Subject: RE: Planning Consultation on BN/23/20/DOC

APPLICATION NO: BN/23/20/DOC

Site Address: Coniston Lake Lane Barnham PO22 0AD

Description of Works: Approval of details reserved by condition imposed under ref BN/23/15/PL relating to Condition No 5 - surface water drainage, 6 - discharge of any flows to watercourses and 7 - future access & Maintenance of any watercourse or culvert

STC DESIGN DEVELOPMENT LTD	
<i>Consulting Structural and Civil Engineers</i>	
Mobile: 07971 404 033	Email: tonyrist@sccdesigndev.com
Title	Scale 1:200 @ A3
AS BUILD DRAWING	4 LAKE LAKE BRANCH
Date	Drawn by
Job no.	Drawing No.
Revision	Revision

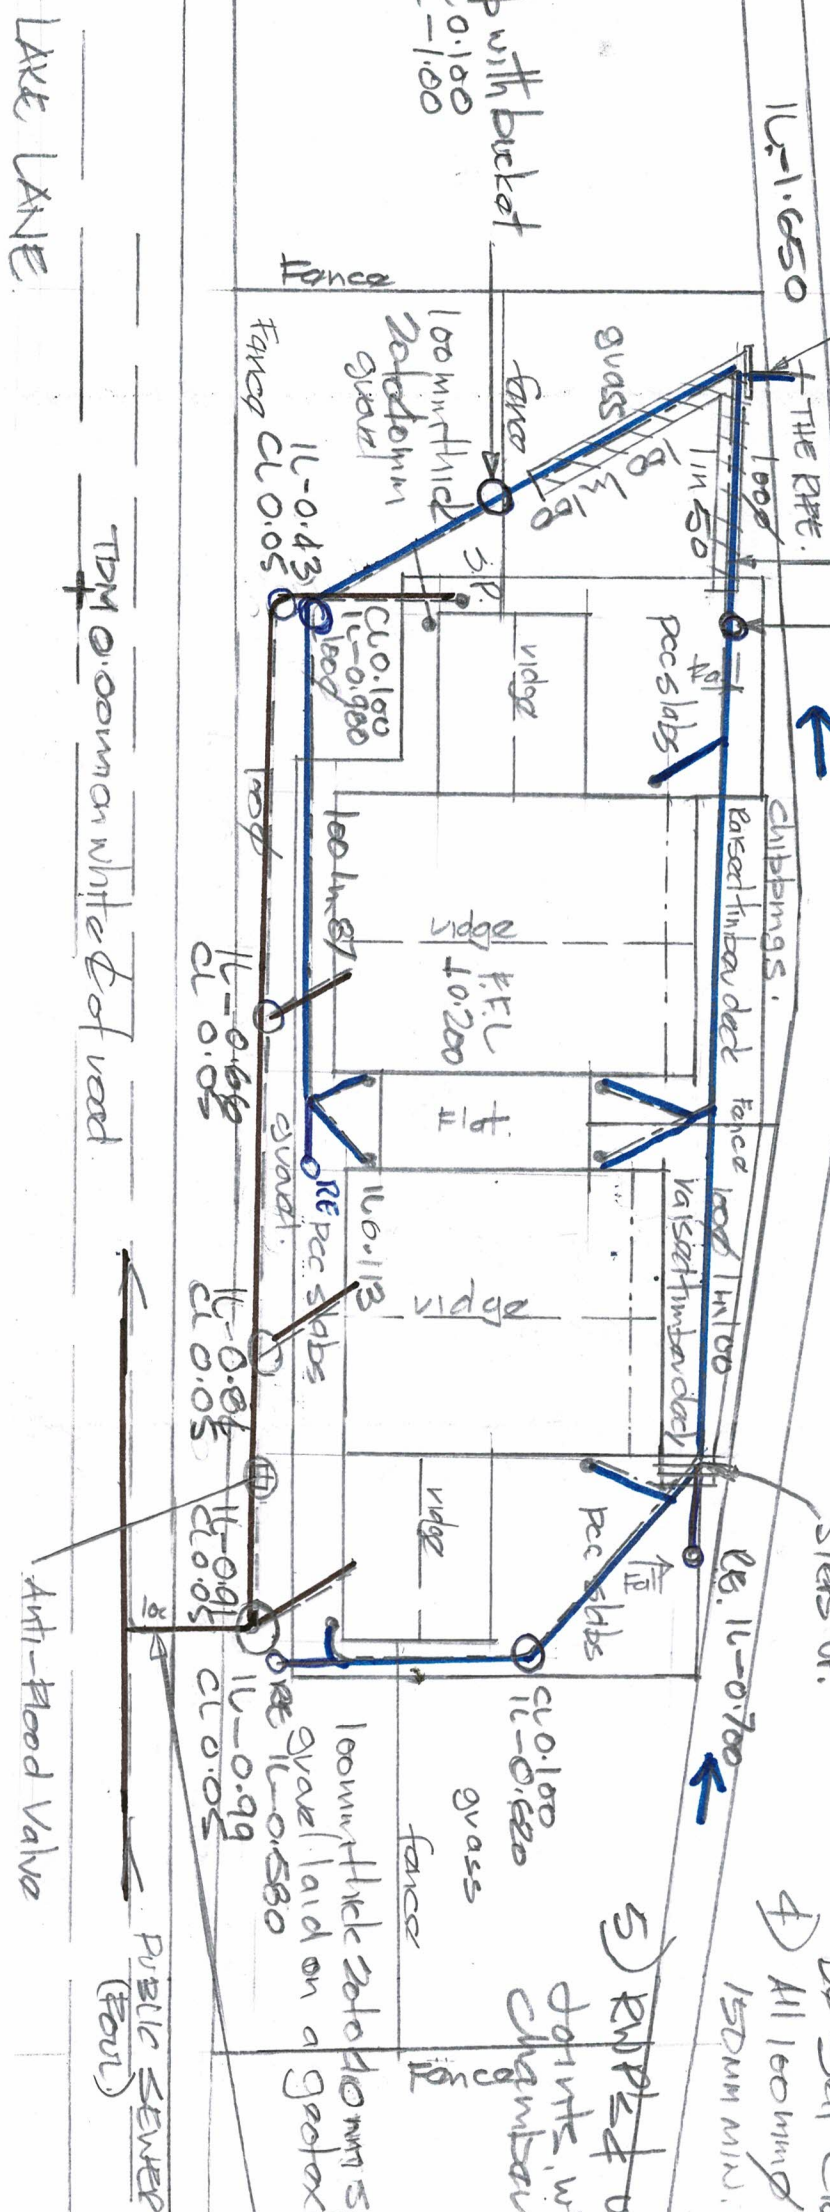
1. RWP connection on east side of building is shown connecting against the flow in the carrier drain. Please clarify what was built and alter drawing accordingly.
2. Rodding eye east side of building (invert level 0.113). Is this the correct level?
3. Revised drawing 535/02 is required in order to address item 2 of my email dated 13.1.20.
